Attachment A

Landscape & Public Domain Clarifications

Clarification of Changes

Public Domain Plan

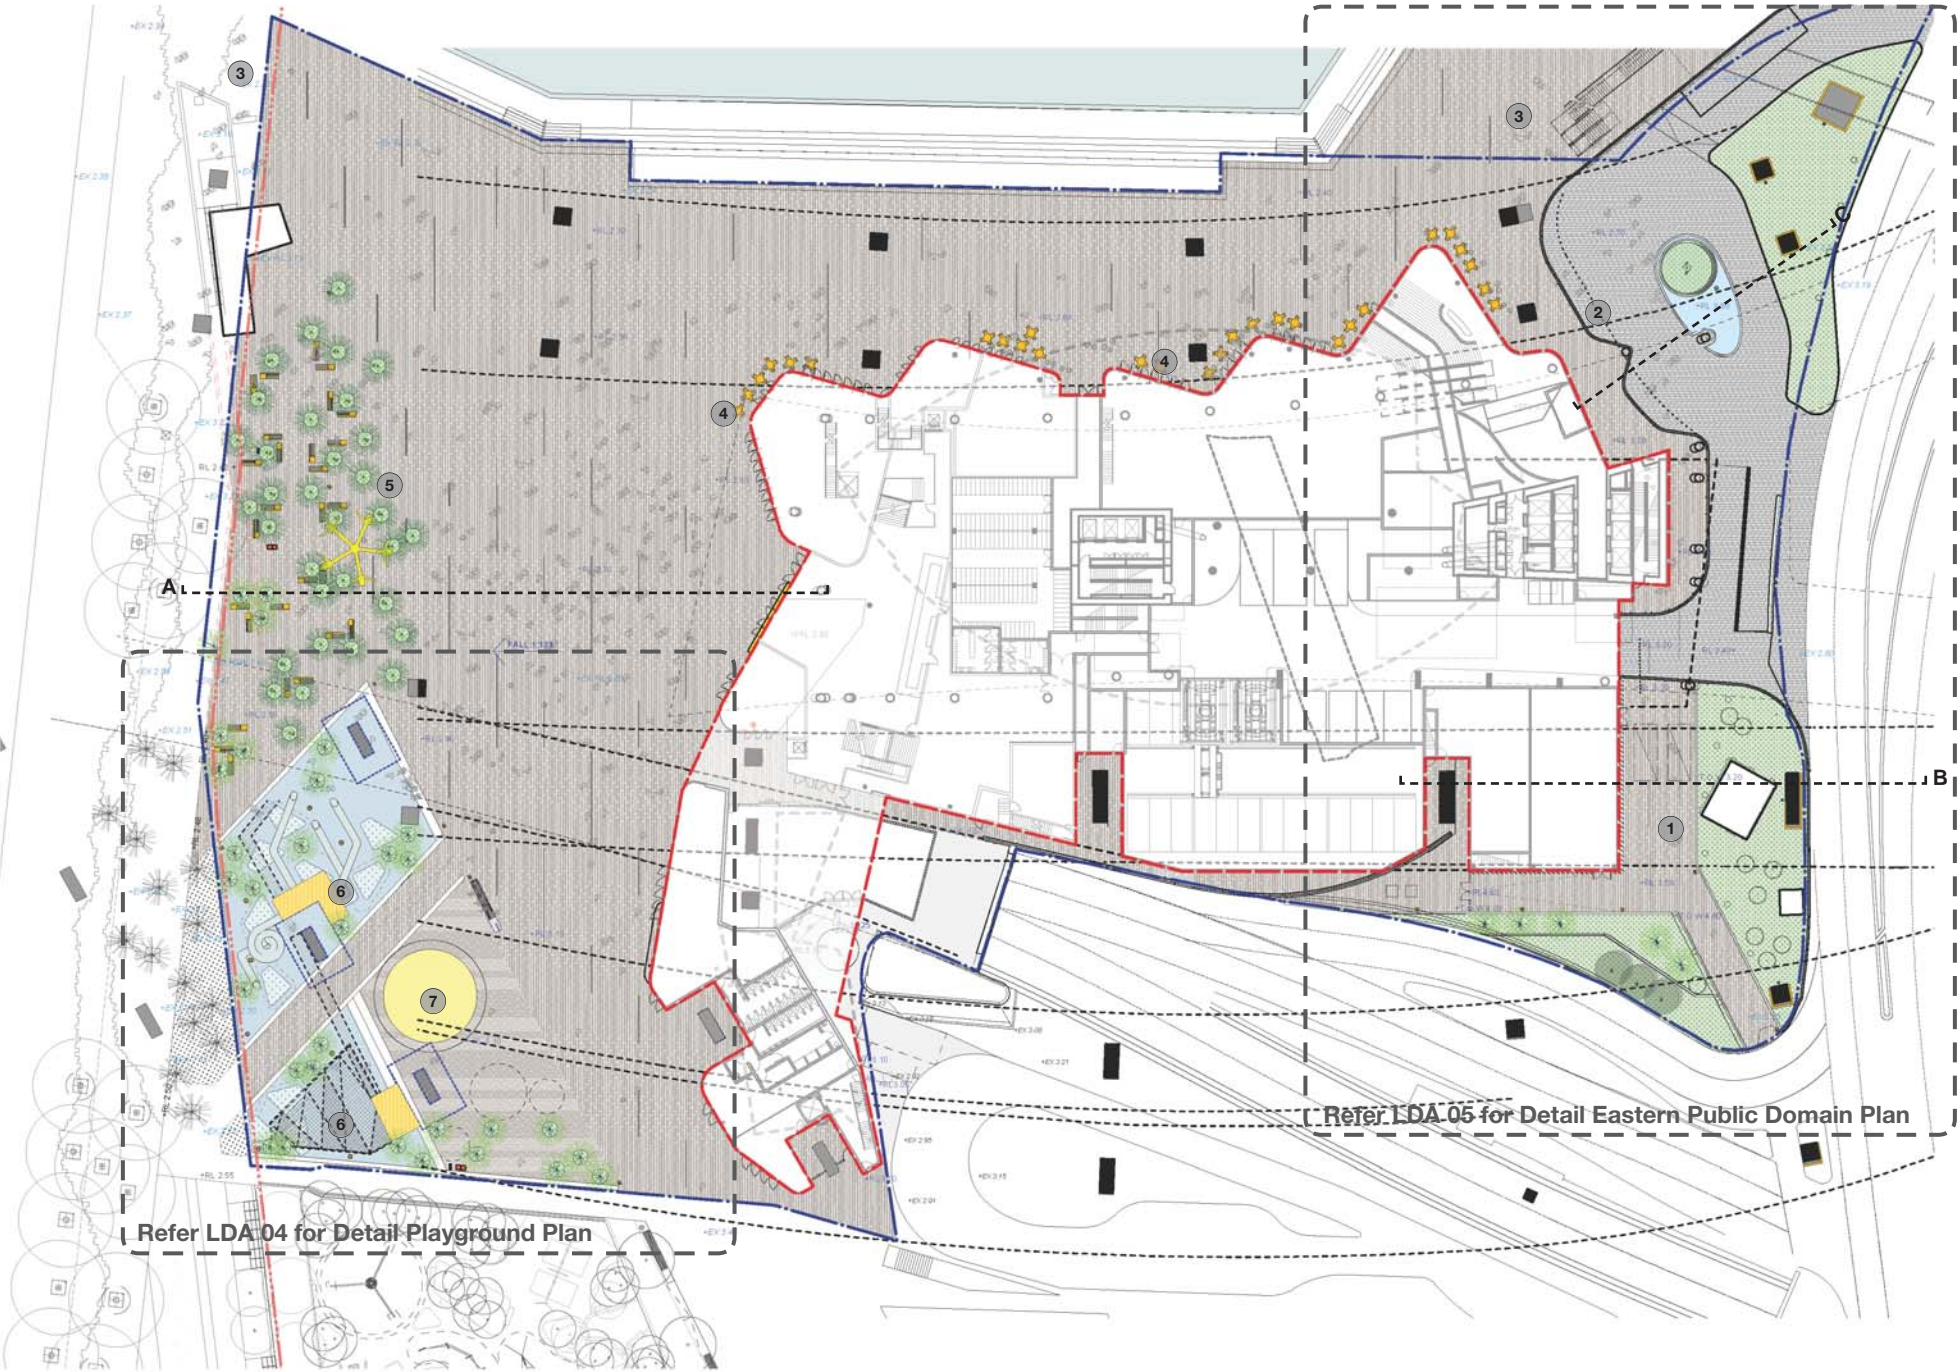
- Removal of the large timber deck to the east of the control building to allow increased circulation space along the waterfront and larger flexible event space.
- Previous DA [Rev F] dimension: approx.10.8m / New dimension: approx.17.7m

- Removal of raised turf area and replace with paving to ensure the continuation of materiality and levels in public domain and allow permeability from boulevard adjacent.
- Propose bespoke seating under relocated palm grove.
- Relocation of Jay Flowers Sculpture to a more prominent/ visible location.

- Removal of climbing net structure and climbing wall to increase permeability from adjacent boulevard and maximise views to harbour.

- Alignment of the west edge of pedestrian boulevard with the existing Darling Quarter playground edge.
- Introduction of flush edge to access relocated carousel and playspace.
- Width of pedestrian boulevard reduced due to increased floor plate of proposed building to the east.
- Previous DA [Rev F] dimension: approx.15m / New dimension: approx.16.5m

- Restricted access to southern edge of hotel as a response to CPTED analysis.
